## Advice to decision maker on coal mining project

### IESC 2022-132: Dendrobium Mine Extension Project (EPBC 2021/9115 and State Ref No SSI-33143123) – Expansion

<b>Requesting agency</b>	The Australian Government Department of Agriculture, Water and the Environment The New South Wales Department of Planning and Environment
<b>Date of request</b>	08 April 2022
<b>Date request accepted</b>	11 April 2022
<b>Advice stage</b>	Assessment

# Predicted profiles of vertical subsidence, upsidence and closure along stream DC8 due to mining in Area 5

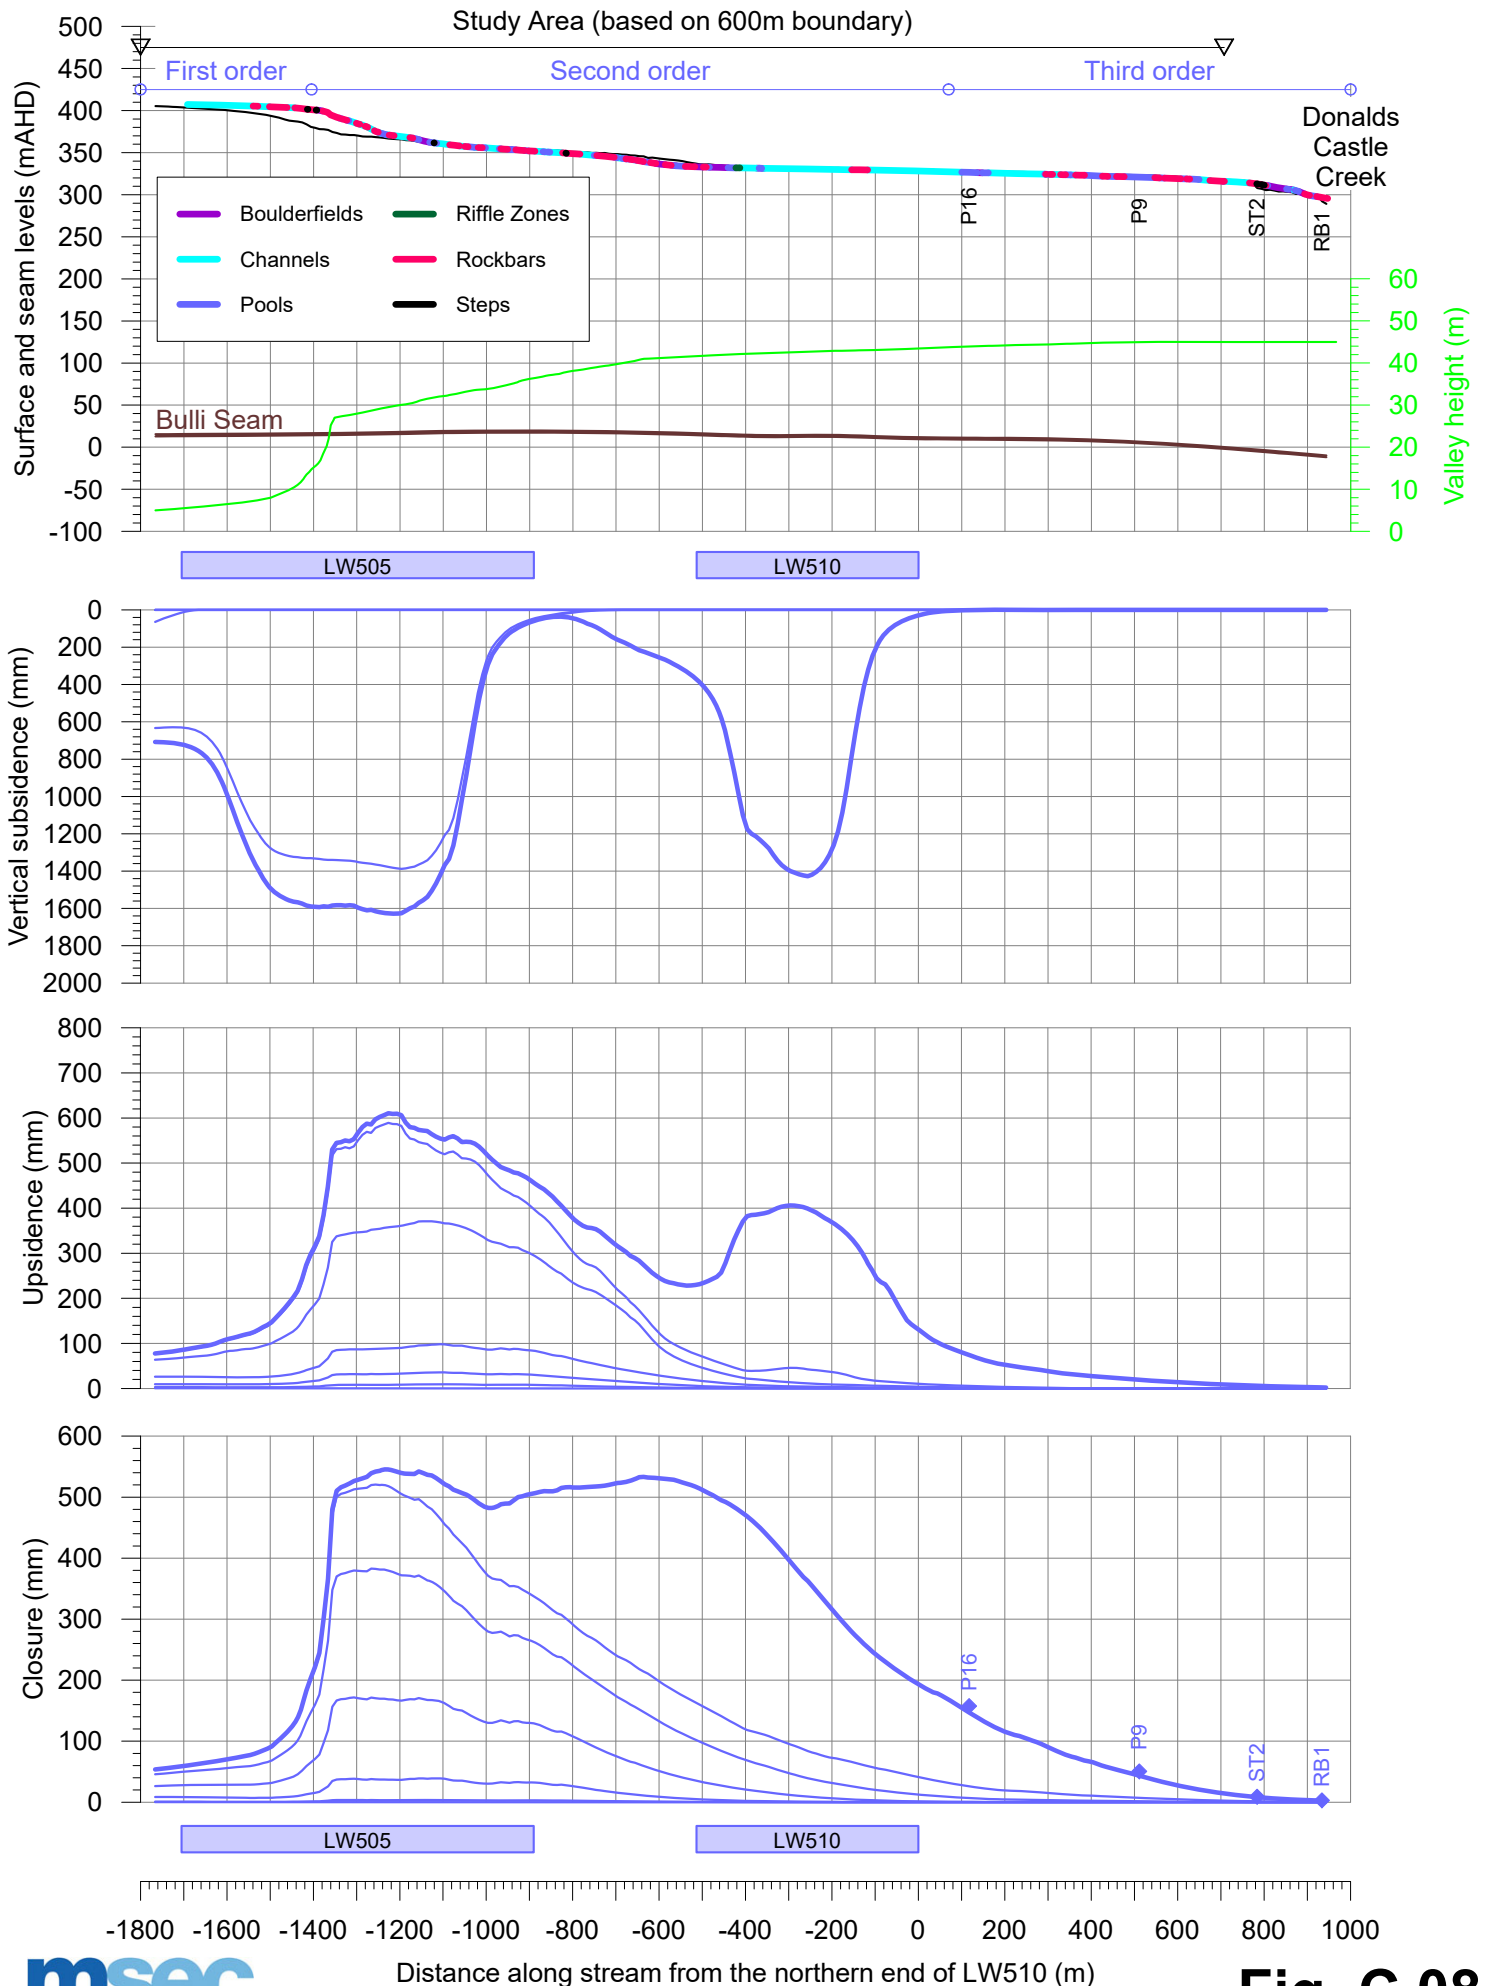
9. The proposed setbacks will not mitigate non-subsidence-related impacts. In particular, the IESC notes that impacts to higher-order streams such as LA13 and Donalds Castle Creek (DC8) are still possible from altered geomorphology and reduced streamflow contributions from impacted first- and second-order tributaries. As these streams occur at lower elevations, connectivity between these streams and the water table is also plausible. Mining-induced drawdown could reduce baseflow contributions and alter water regimes in LA13 and DC8 regardless of setback distances. Collectively, these impacts could still result in significant impacts, particularly to LA13 which remains surrounded by proposed longwalls.
